From: Carly Miskell
Sent: 05 April 2022 08:38
To: Planning; Sarah Heppell
Subject: FW: Consultation on planning application, 3/2022/0047, Cuthbert Hill Farm Garstang Road Chipping

From: David Hewitt <David.Hewitt@ribblevalley.gov.uk> **On Behalf Of** Countryside
Sent: 04 April 2022 15:00
To: Carly Miskell <Carly.Miskell@ribblevalley.gov.uk>
Subject: RE: Consultation on planning application, 3/2022/0047, Cuthbert Hill Farm Garstang Road Chipping

The application is for - New access to the highway (following the blocking off of existing) and extension to existing agricultural building.

SITE PLAN SCALE 1:500

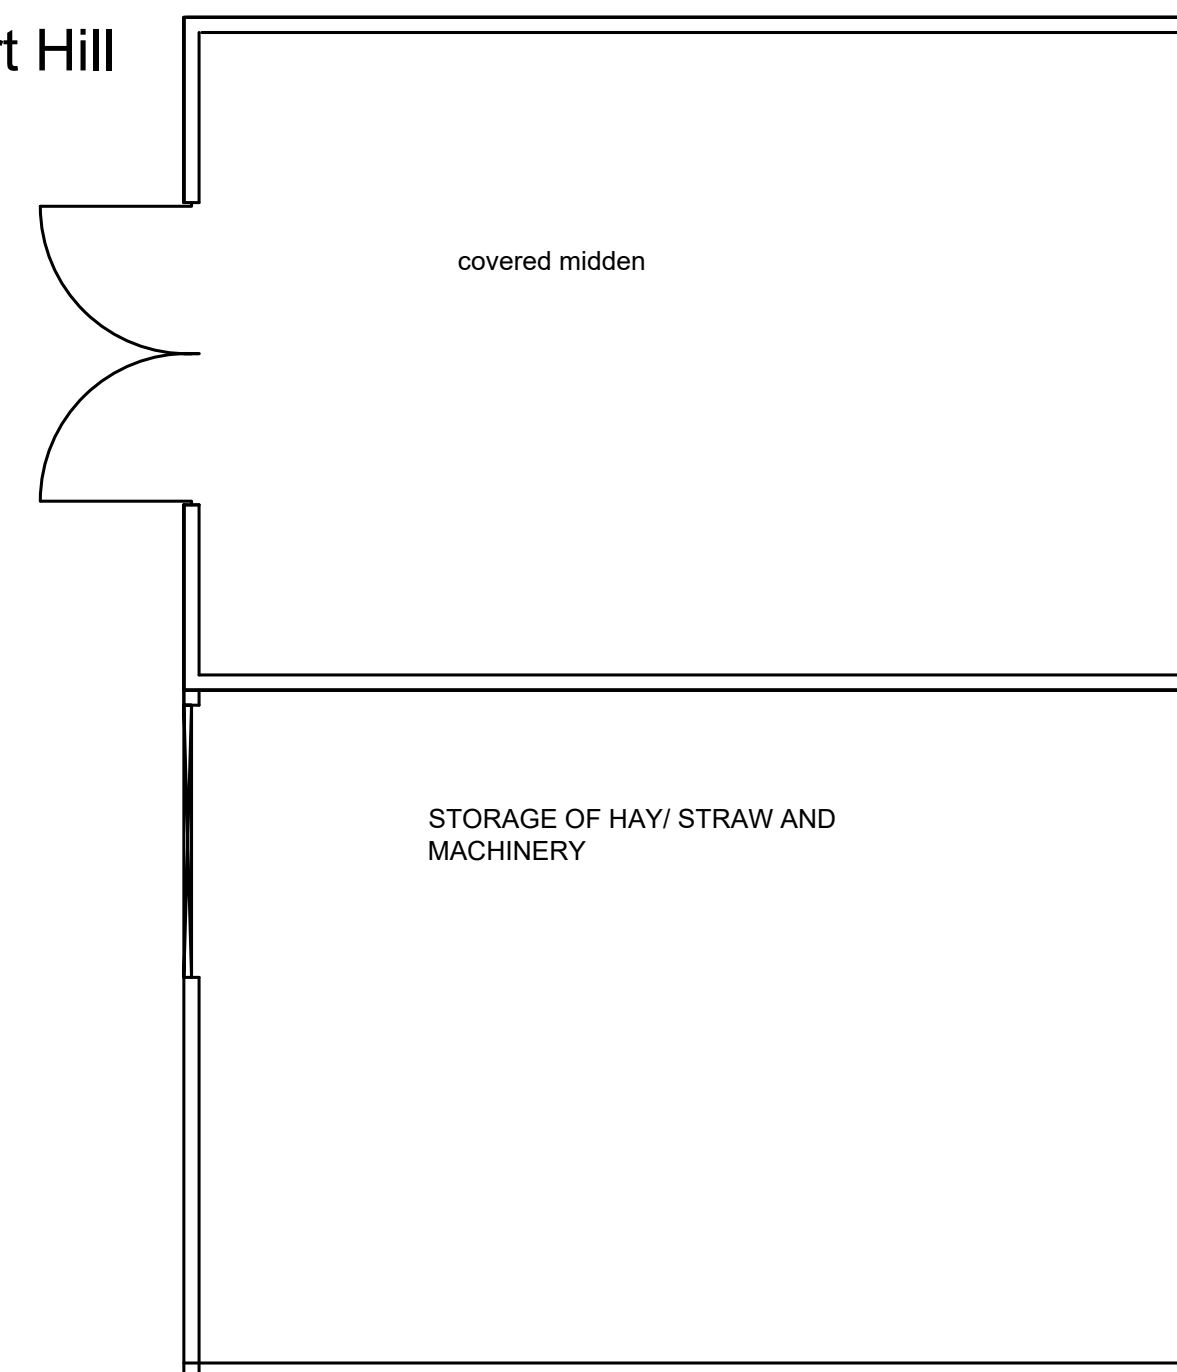
This will require a condition for a Lancashire hedgerow mix for the visibility splay
